**Response to Deadline 3 submissions  
for the  
Royal Society for the Protection of Birds  
Summary of Response to Deadline 3 Submissions  
Submitted for Deadline 4  
25 April 2025**

**Application by North Falls Offshore Wind Farm Limited for an Order  
Granting Development Consent for the North Falls Offshore Wind Farm**

**Planning Inspectorate Ref: EN010119  
RSPB Registration Identification Ref: 20051053**

Figure 2 Outer Trial Bank

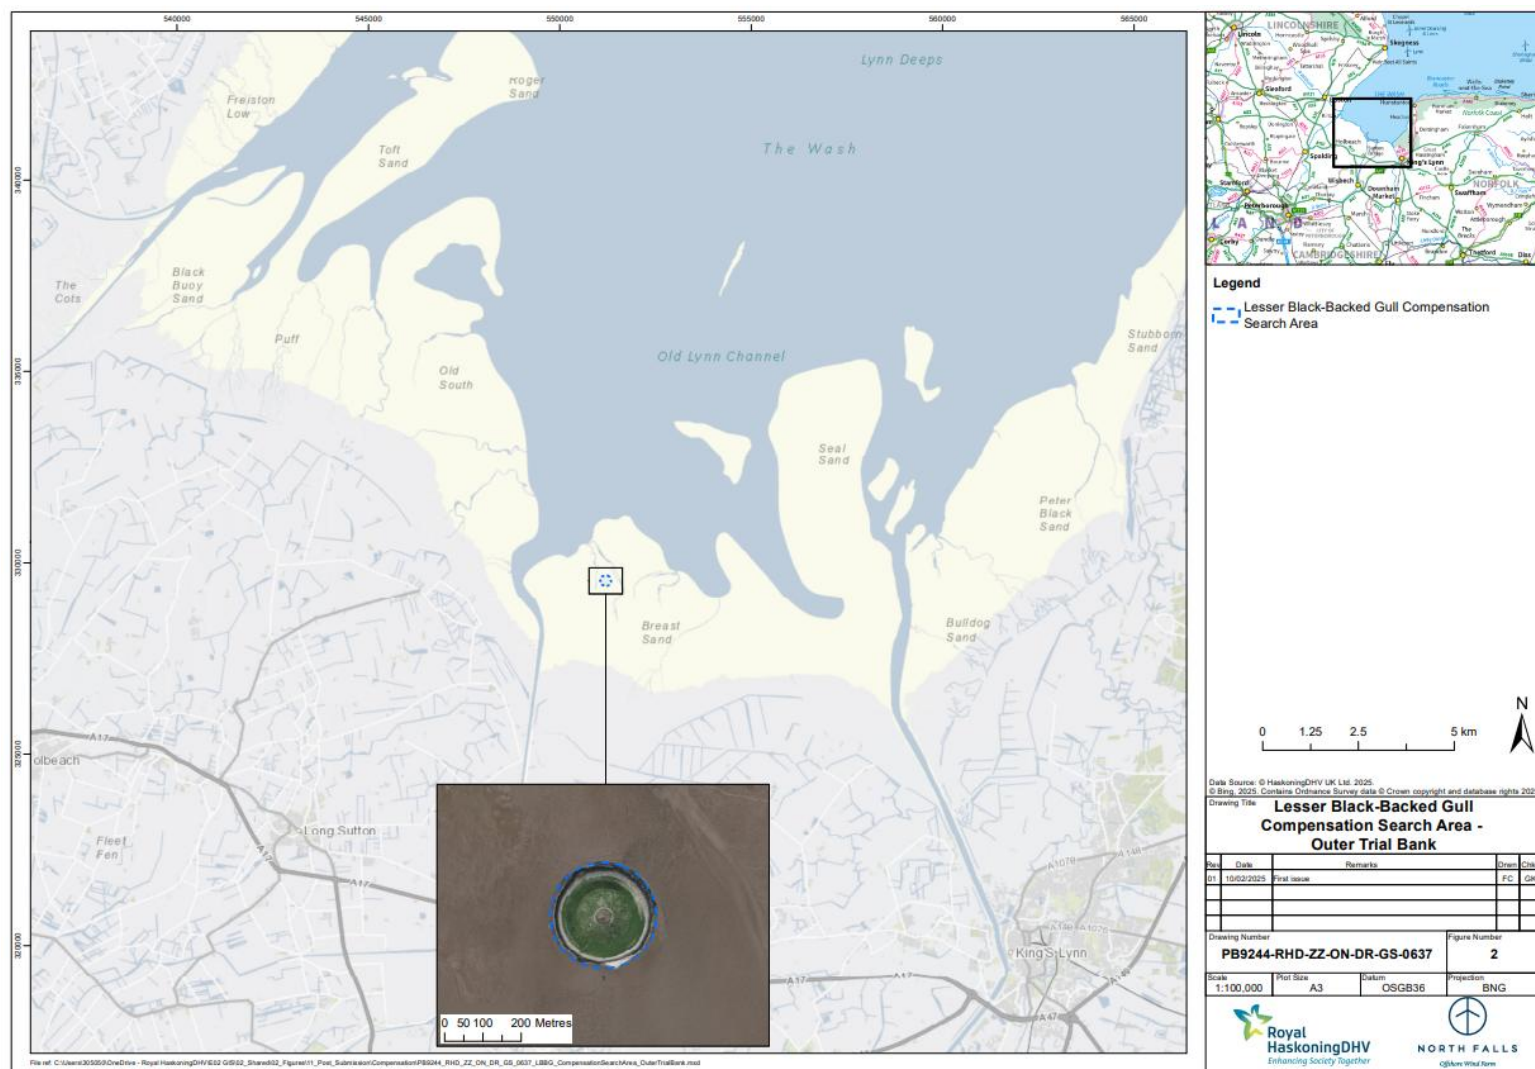
- o RSPB will continue to engage with the Applicant regarding compensatory measures options, including discussions over site suitability, nesting densities and productivities.
- o RSPB regard the Outer Trial Bank compensatory measures option as requiring more investigation and based on the available information, cannot see how it is capable of progression as compensation.
